Our Ref: WA/70/20/DOC

Town & Country Planning Act 1990 (as amended)
Town and Country Planning (Development Management Procedure) (England) Order 2015
Approval of details reserved by condition imposed under ref WA/44/17/OUT relating to Condition No 6 -
Construction Management Plan.
Land East of Tye Lane Walberton

The information submitted regarding Condition 6 imposed on outline planning permission WA/44/17/OUT: relating to a Construction Management Plan is refused.

Scale AS SHOWN	Date MAY 2020	Designed by KI
Drawn by KI	Checked by DH	Approved by KM
Drawing Number 183244-001		Rev -

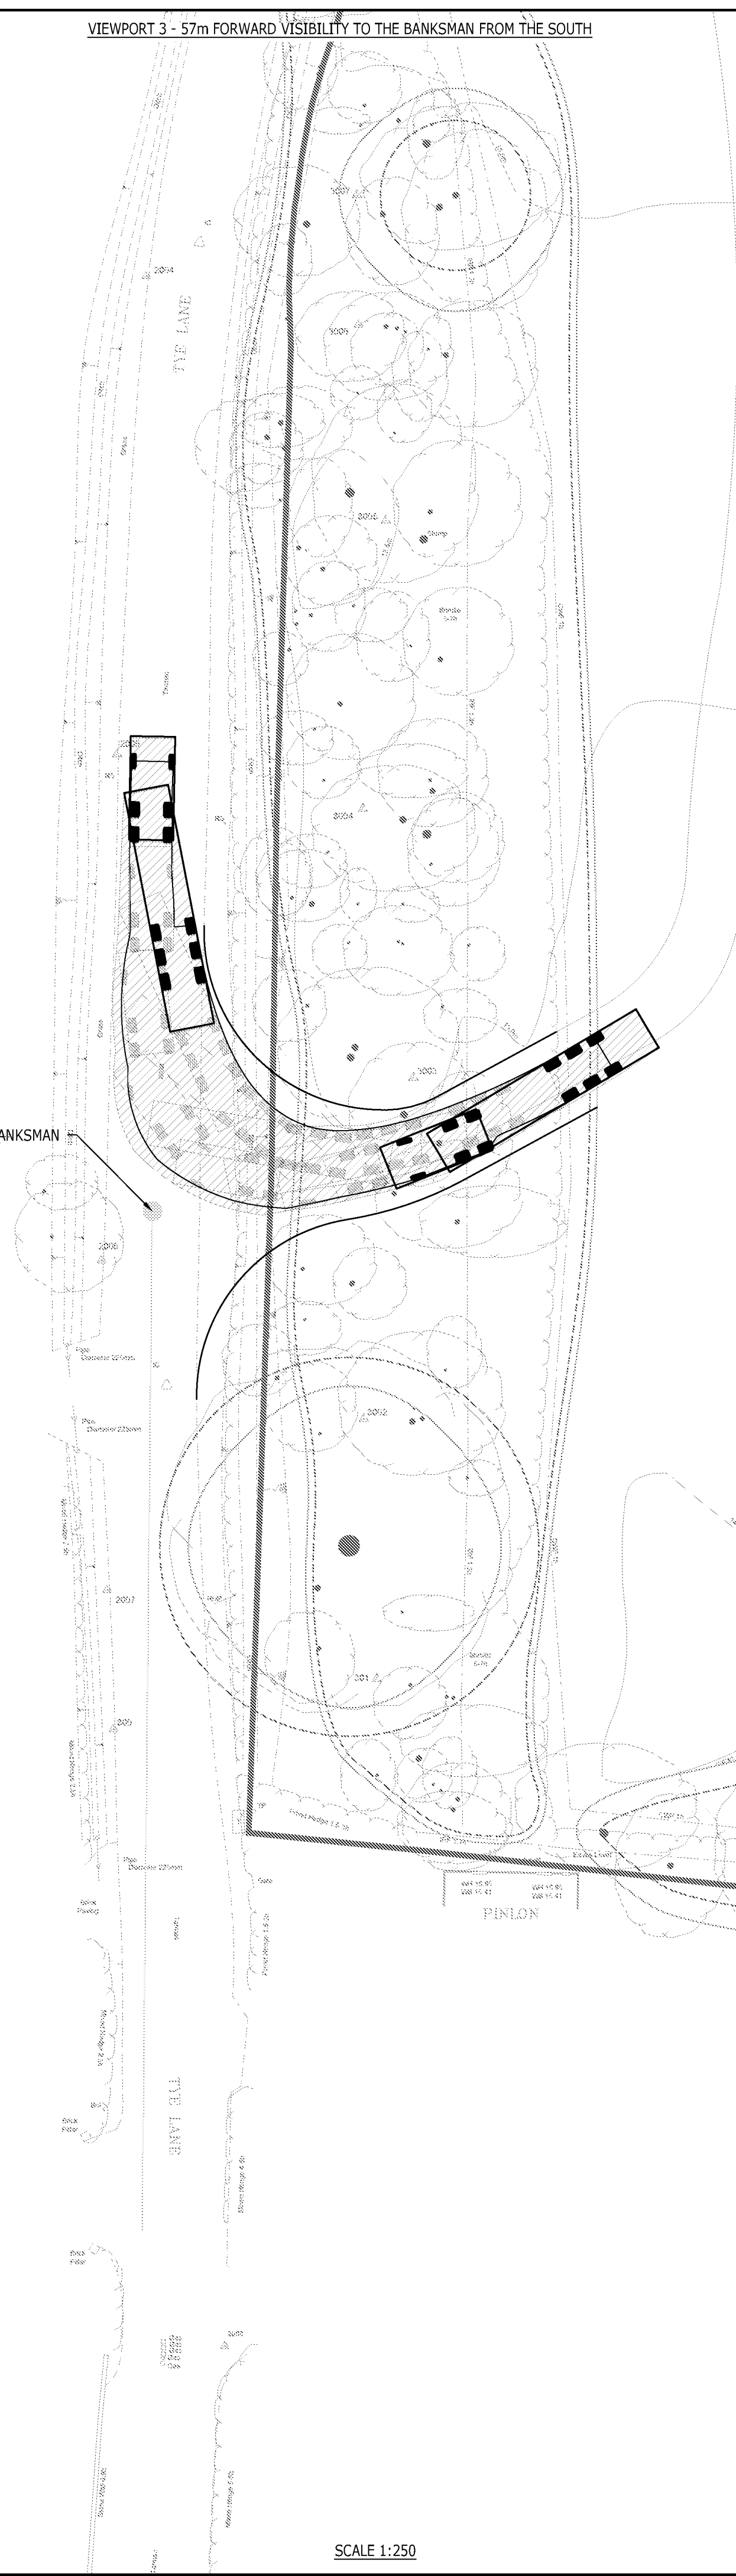
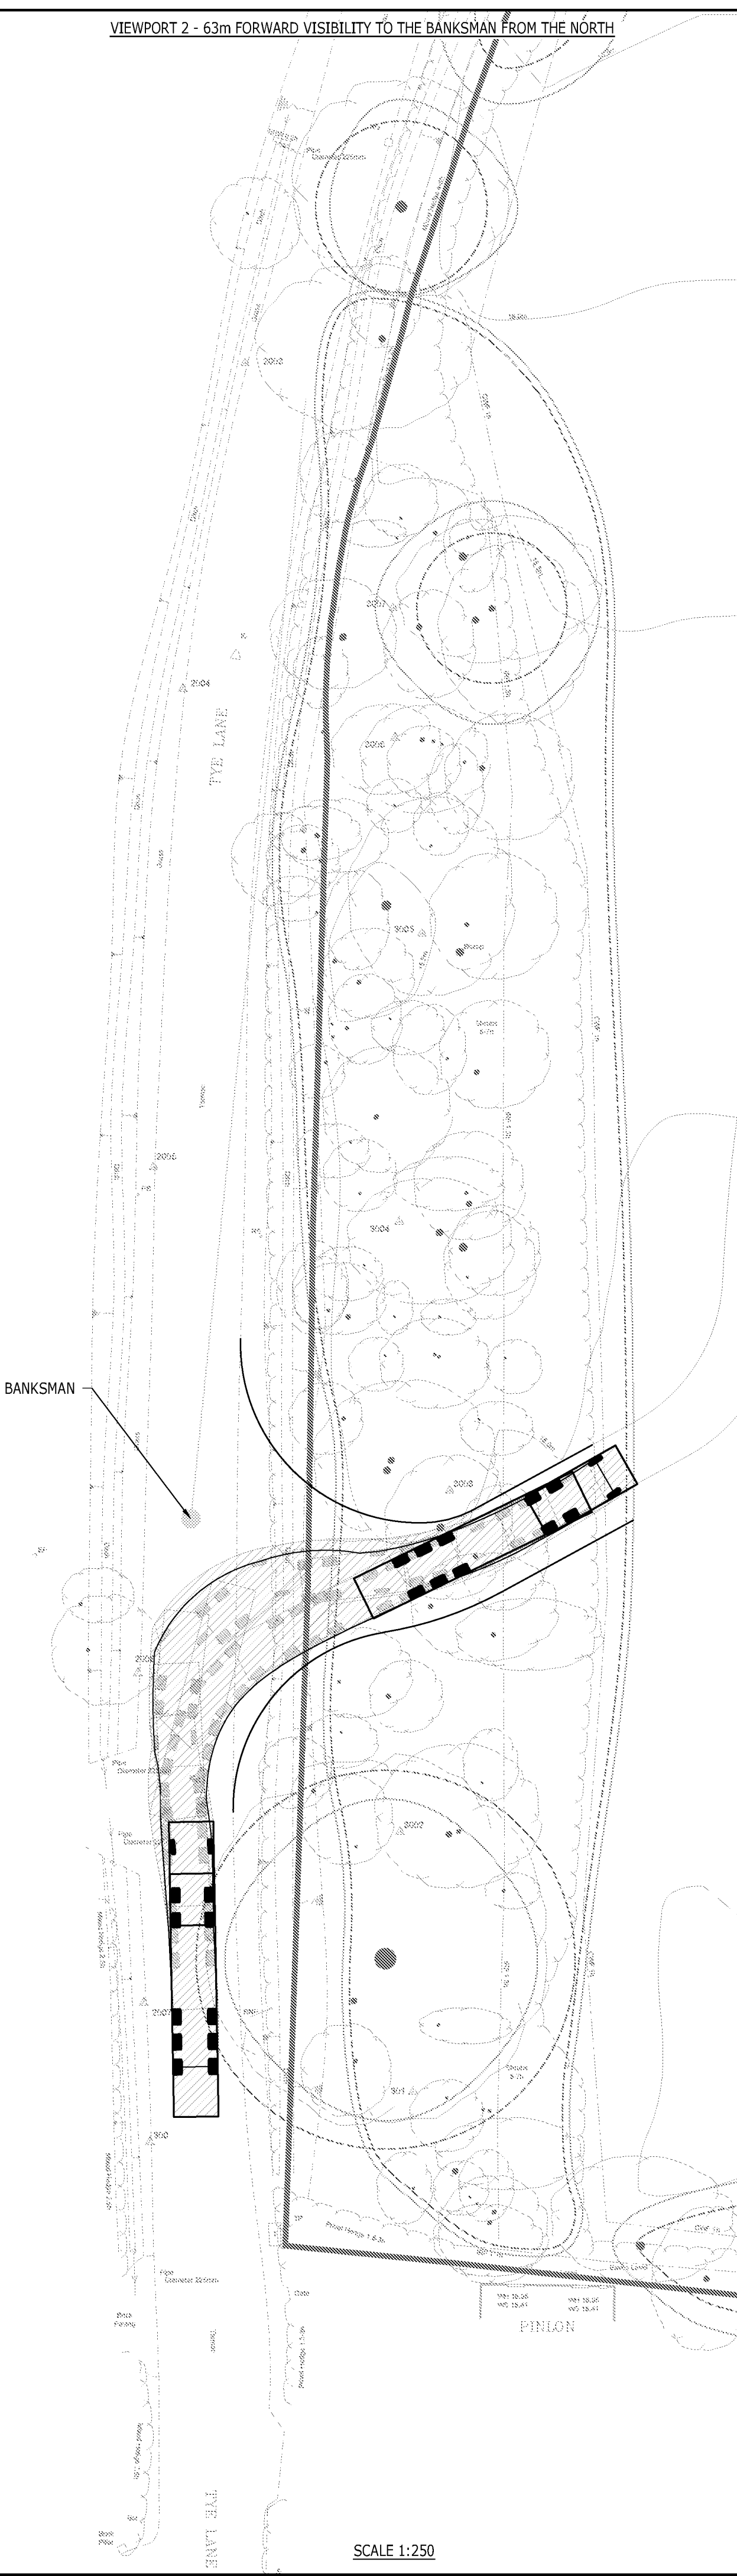
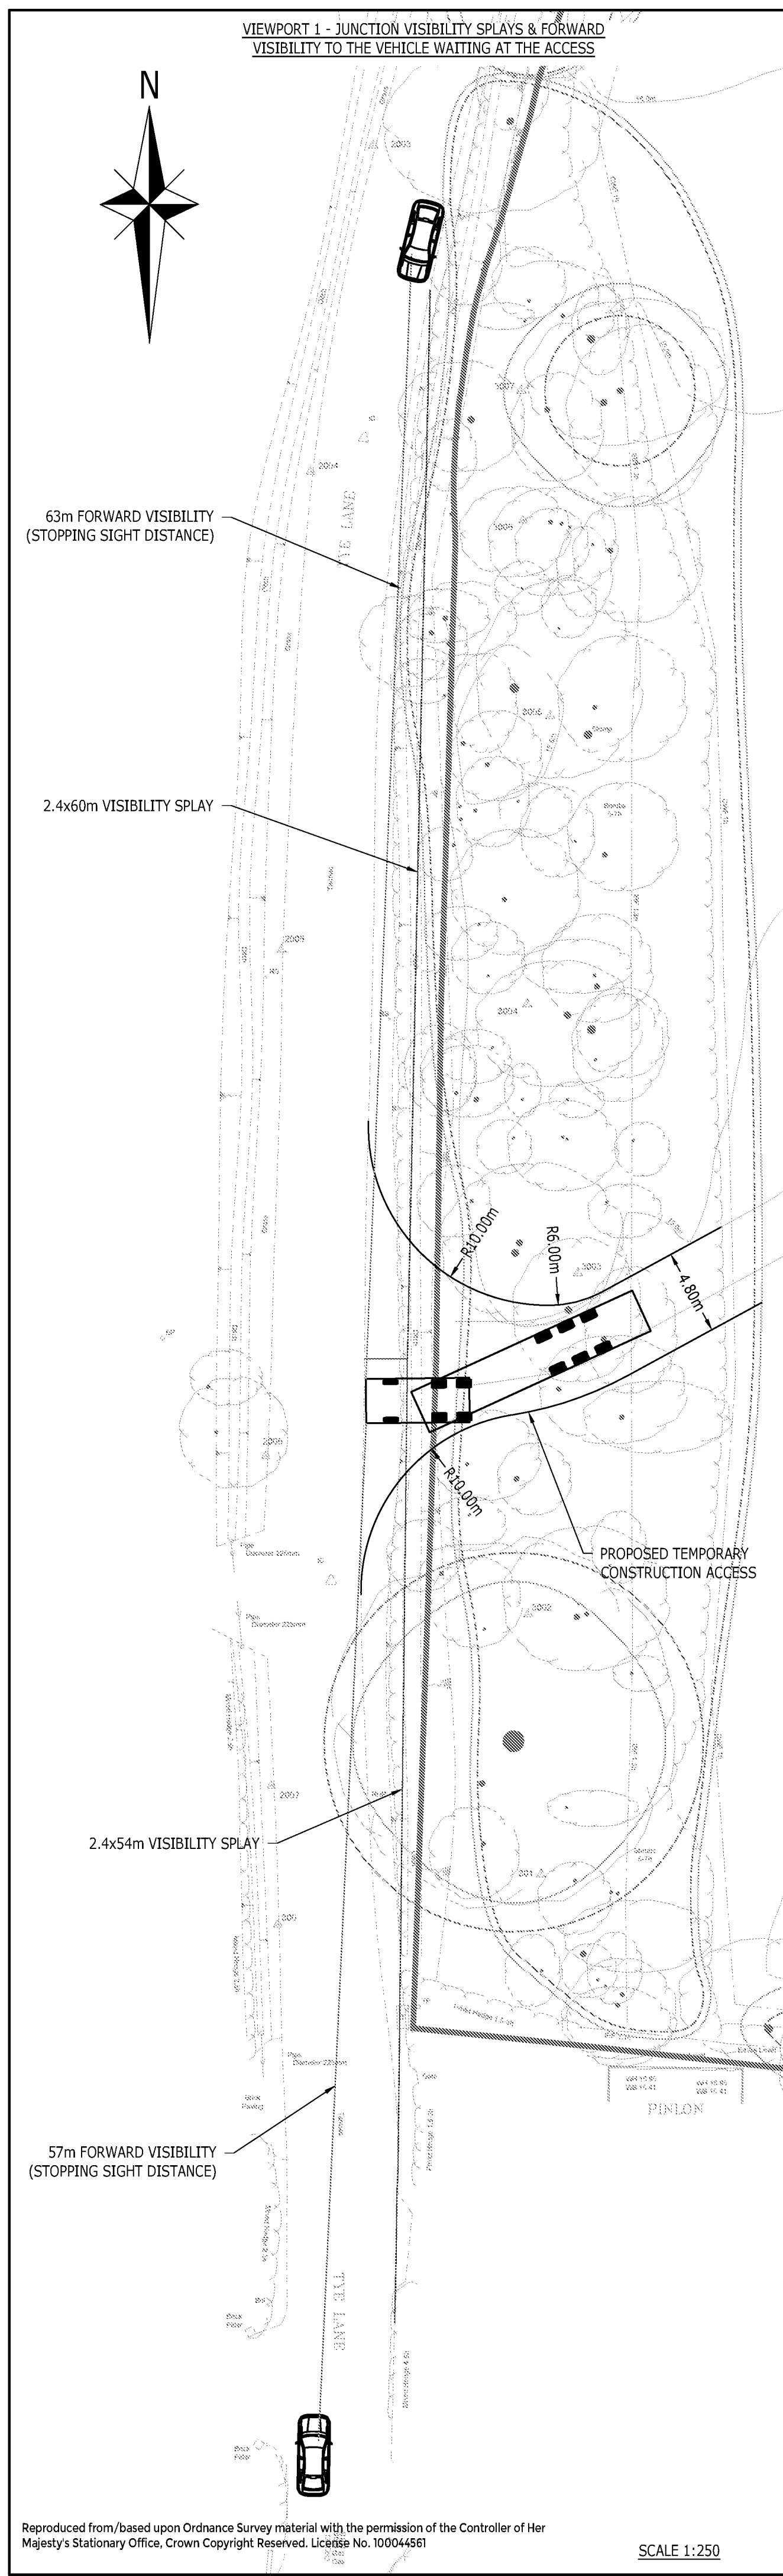
With the proposed change to construction traffic routeing, all construction traffic to and from the A27 would use the A27 / Tye Lane junction instead of the A27 / Yapton Lane junction. The Tye Lane access onto the A27 is not suitable for heavy construction vehicles: there is no acceleration lane or merge taper and so heavy, slow accelerating construction related vehicles would be pulling out into a high speed road from a standing start. This is not acceptable because of the inherent safety risk of heavy, slow moving traffic entering the A27 carriageway and conflicting with high speed traffic on the main line. Therefore all heavy construction traffic accessing the A27 should use the Yapton Lane junction where there is an appropriate acceleration merge taper.

Heavy, construction related traffic from the site should not turn into the A27 at Tye Lane because of the inherent safety risk. The developer would not be able to manage, monitor and enforce a restriction preventing heavy construction vehicles using the A27 / Tye Lane junction to enter the A27.
